Application no: **3/2024/0278**

Address: **New Barn Farm Alston Lane Longridge PR3 3BN**

Proposal: **Proposed demolition of existing mixed use building and garages and erection of one replacement mixed use building for domestic garaging, equine storage and agricultural machinery.**

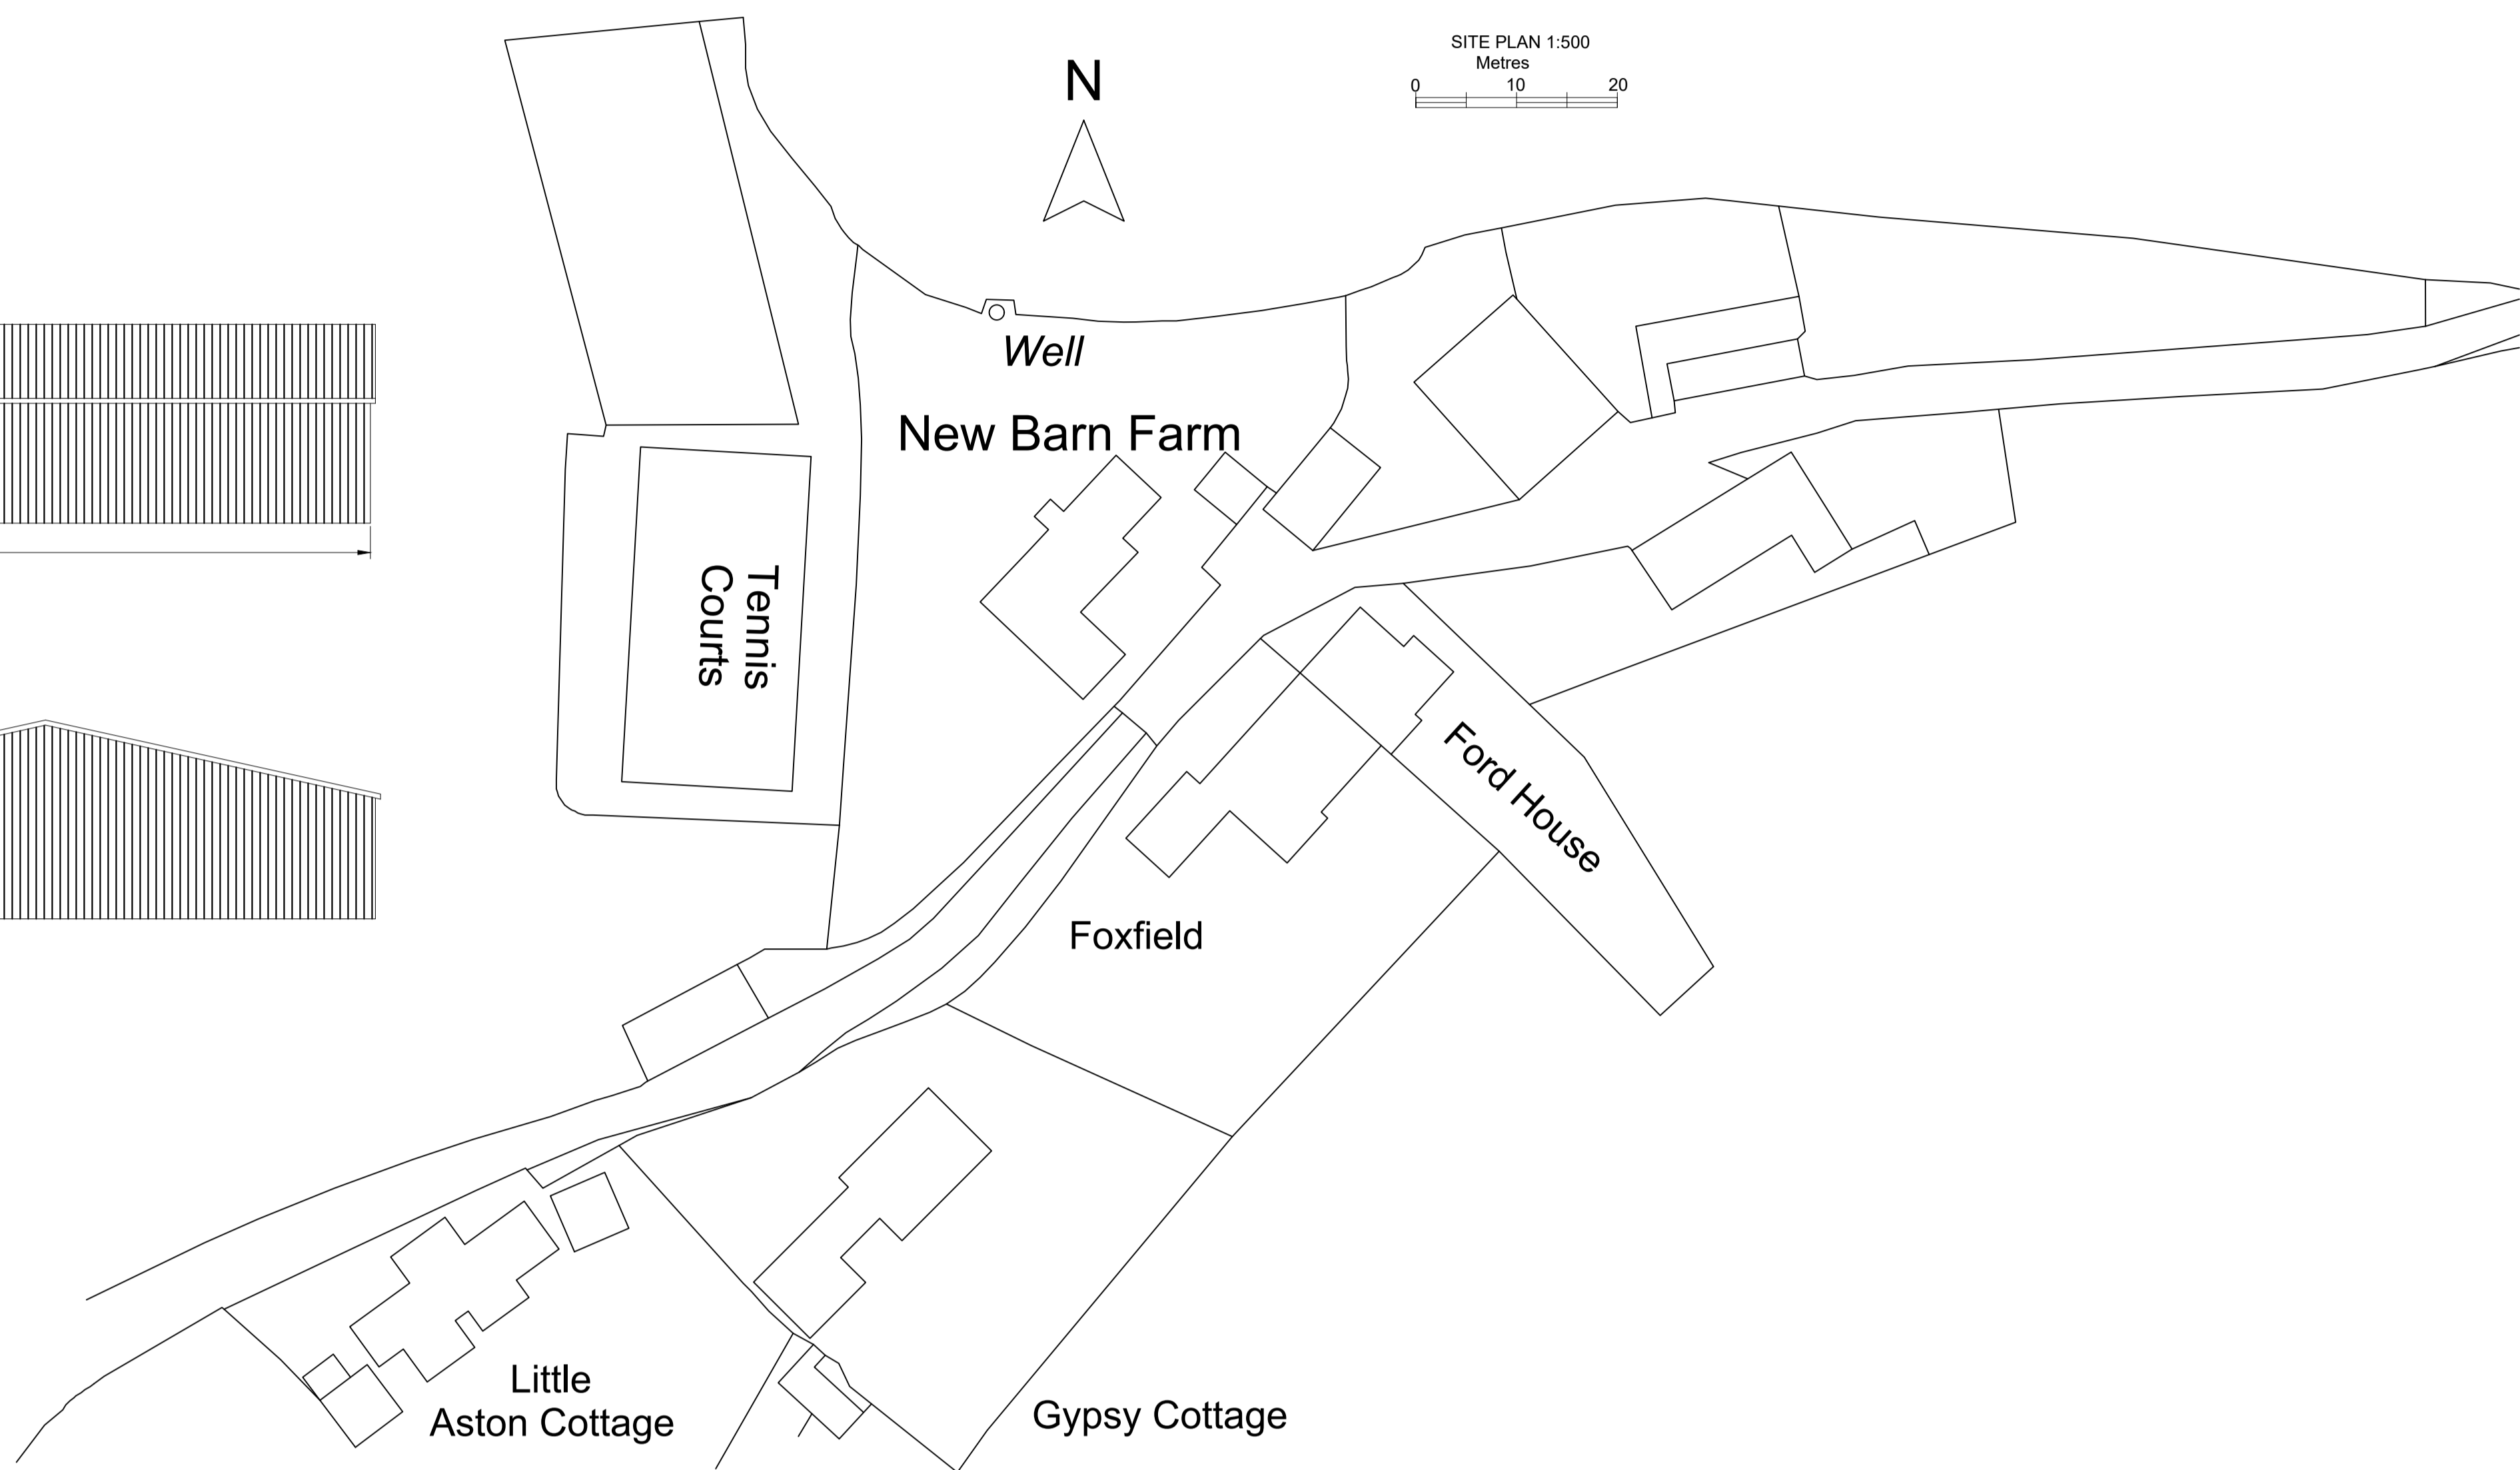
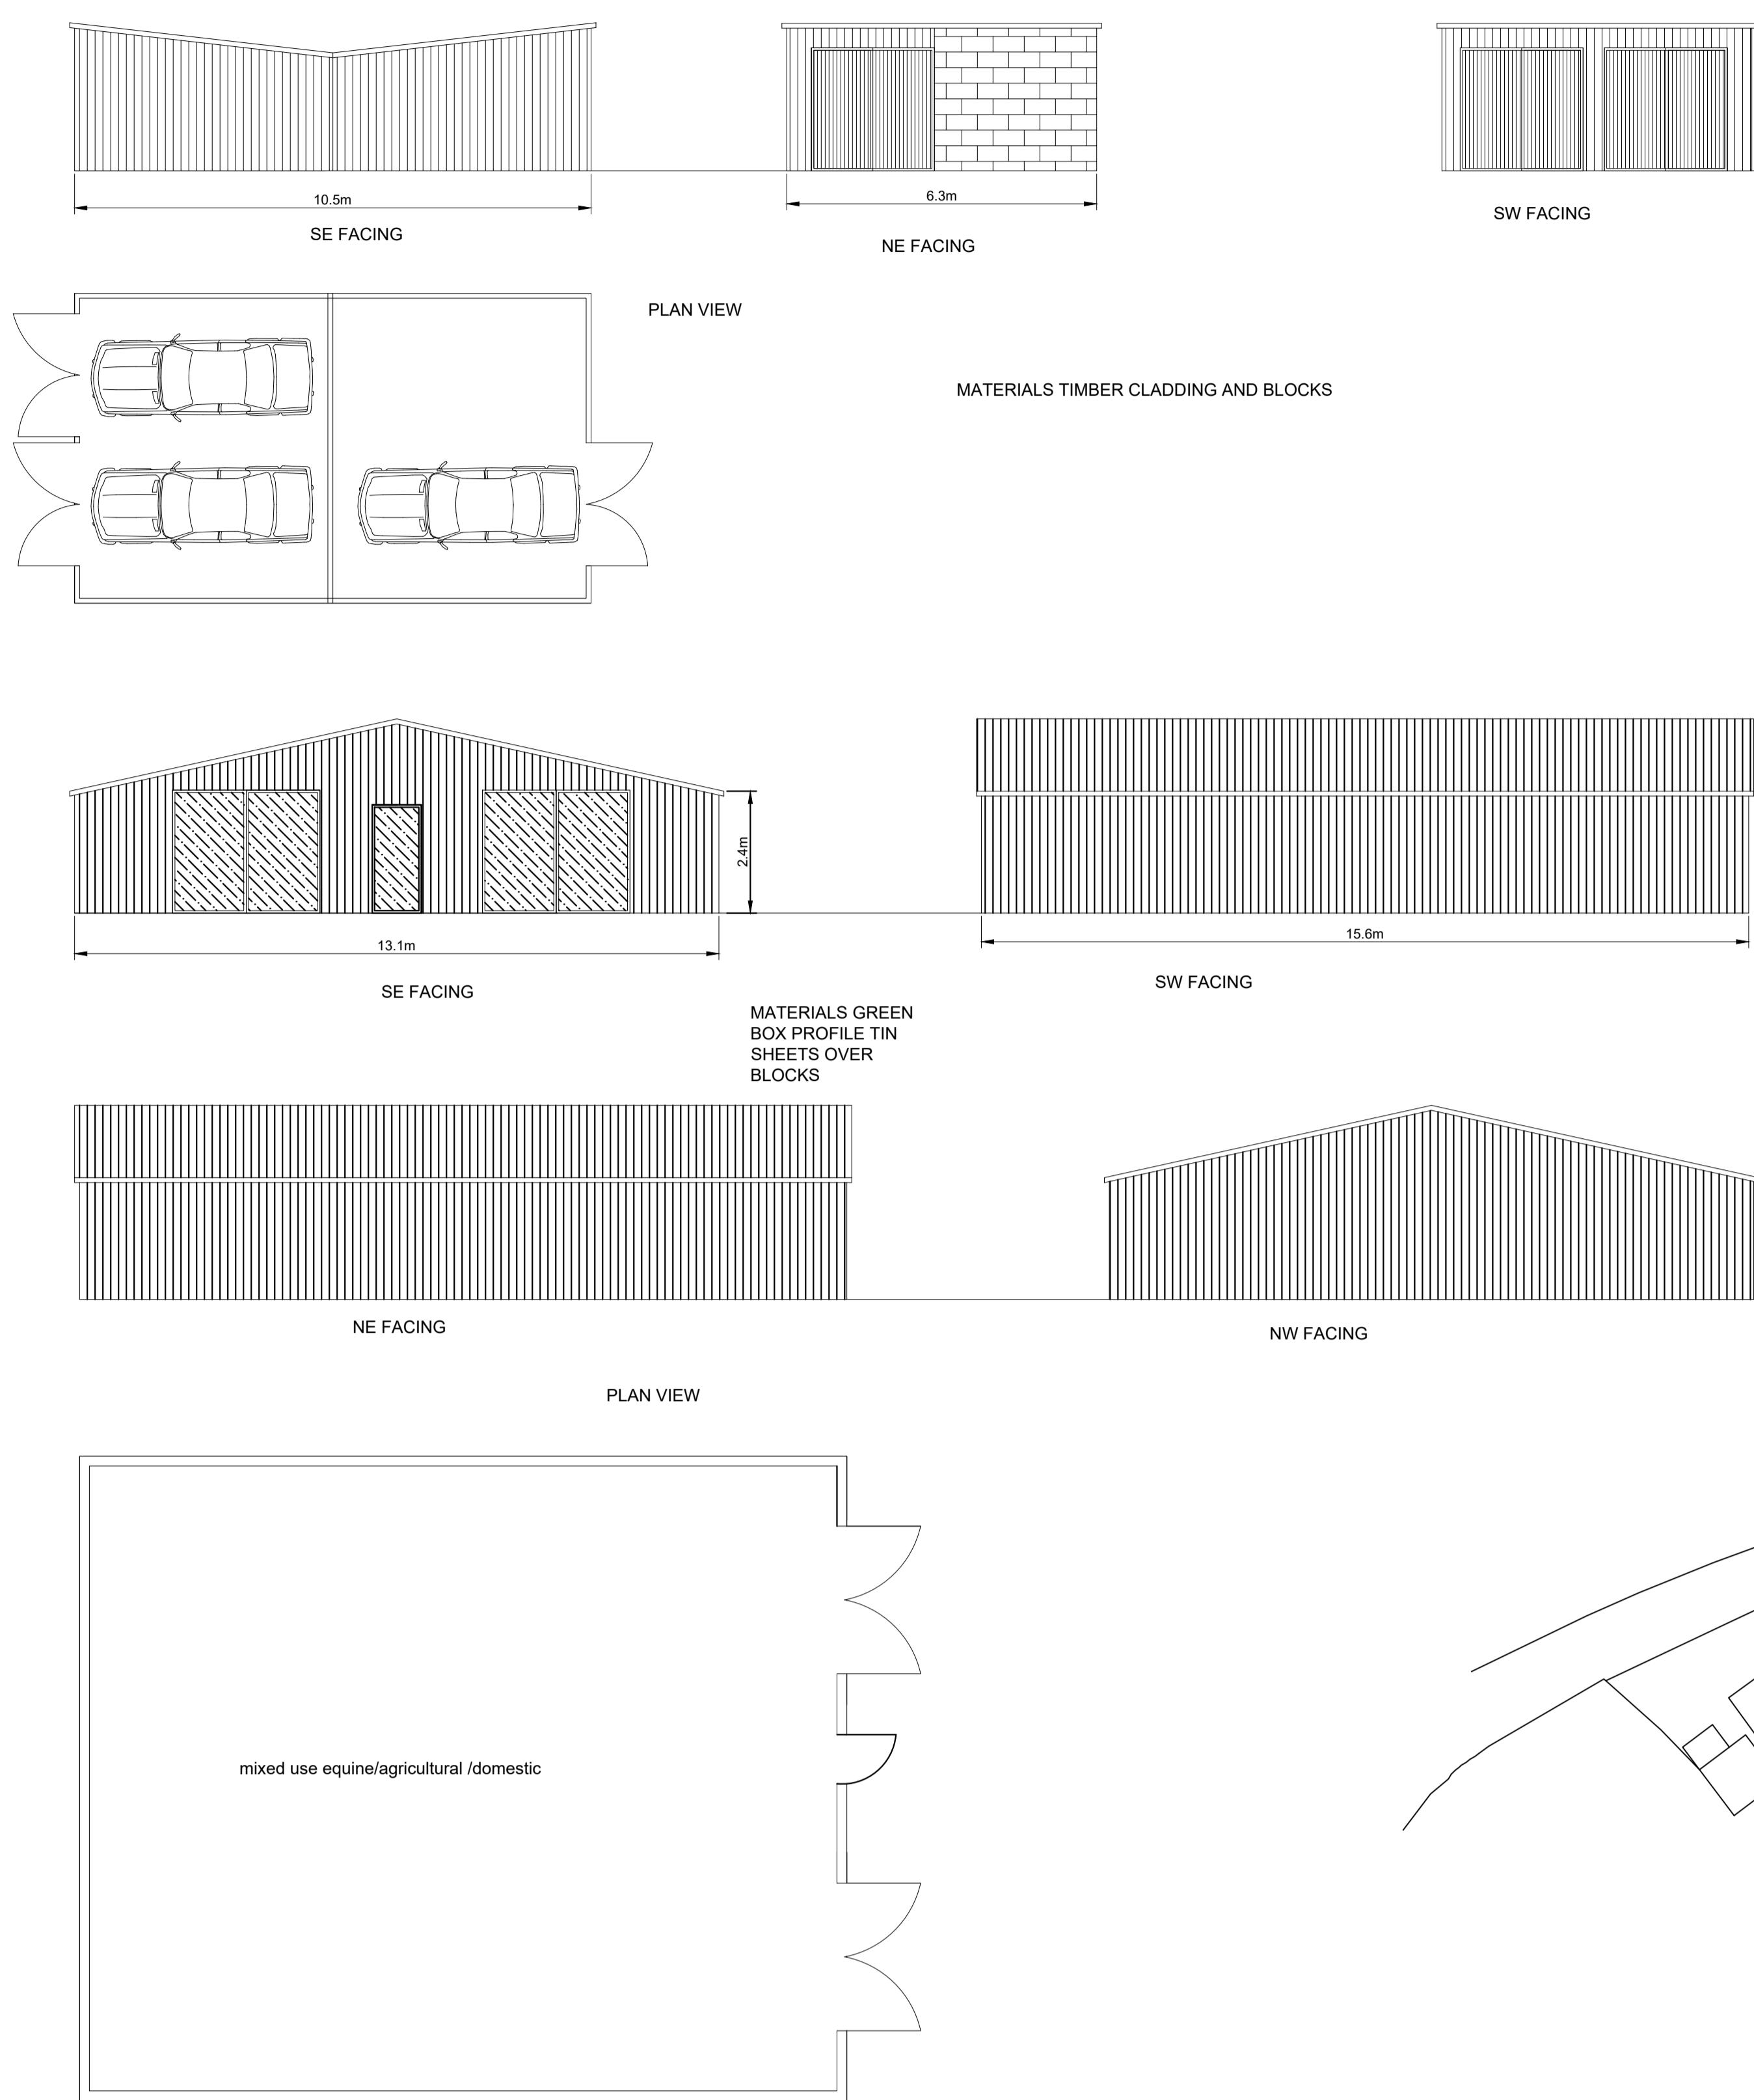
The LHA have reviewed ML drawing number ML/PE/6326 and require further information regarding the size of the existing and replacement building. This is because should the replacement building be bigger than the existing building, the proposal may conflict with the definitive line of the Public Right of Way, FP0302073 which runs past the existing building into the adjacent field to the north. As a result of this, to ensure that there is no conflict with the Public Footpath following the proposal, the LHA require an amended plan showing the proposed building in relation to the Public Footpath.

The LHA require an amended plan to be submitted showing the location of the proposed building in relation to Public Footpath FP0302073, which runs past the existing building into the adjacent field to the north. This is to ensure that the footprint of the proposed building does not conflict with the Public Right of Way.
